Deadline 3 Submission by National Highways Limited

NH Response to Written Questions

Application by The Drovers Solar Farm Limited for an Order granting Development Consent for the construction, operation, maintenance, and decommissioning of a solar photovoltaic (PV) electricity generating station, including associated development comprising a Battery Energy Storage System (BESS), ancillary infrastructure, a customer substation, and grid connection infrastructure (including a new National Grid substation).

Planning Inspectorate Reference Number: EN0110013

Figure 4-1 Proposed Construction Routing Overview

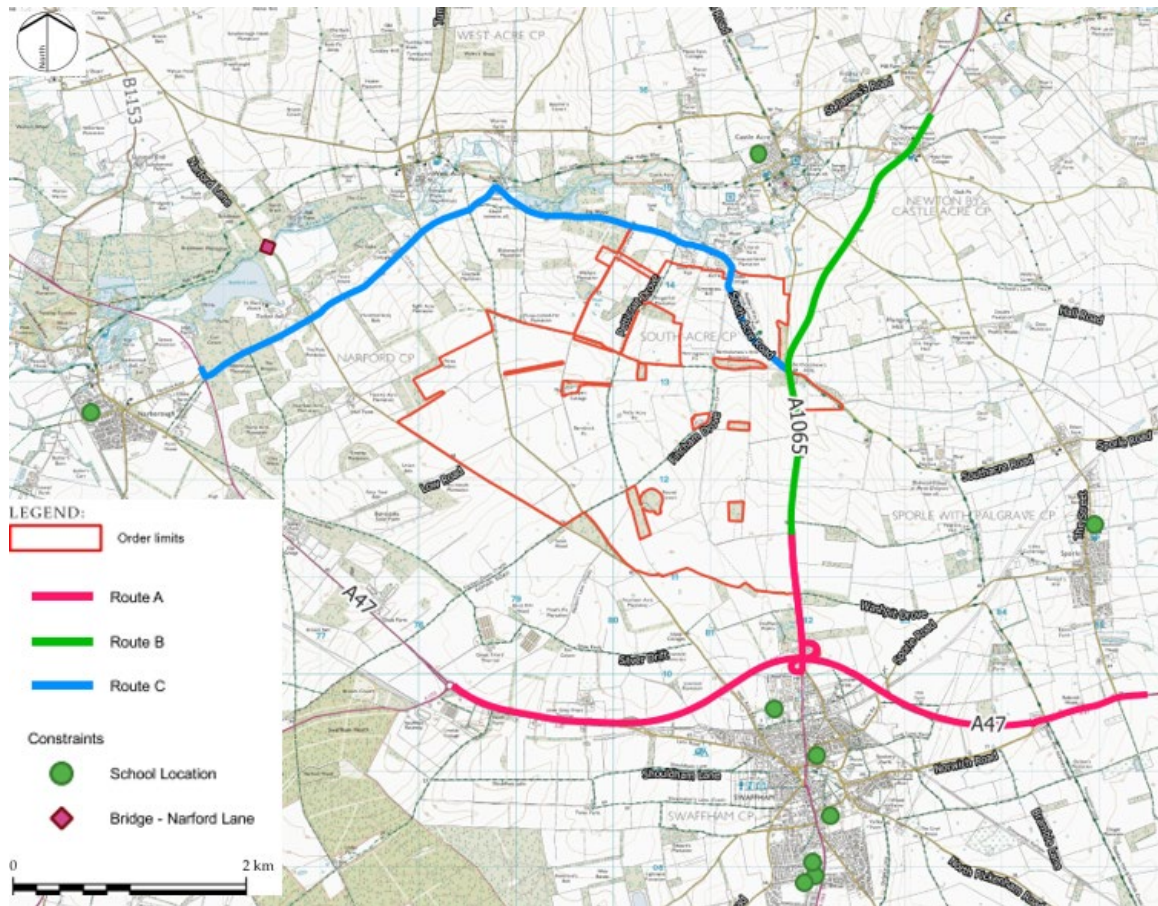
- 2.2.9 Chapter 7 of the OCTMP confirms Abnormal Indivisible Loads (AILs) will be required and are expected to use the A47. NH's Water Preferred Policy applies, meaning loads should arrive via the nearest suitable port. While the AIL route has been agreed in principle, final approval must be secured through the ESDAL process, which may override earlier agreements.
- 2.2.10 Minor works at the A47/A1065 junction are proposed to accommodate AILs. Although accepted in principle, these require a Road Safety Audit and technical approval, with any recommendations addressed
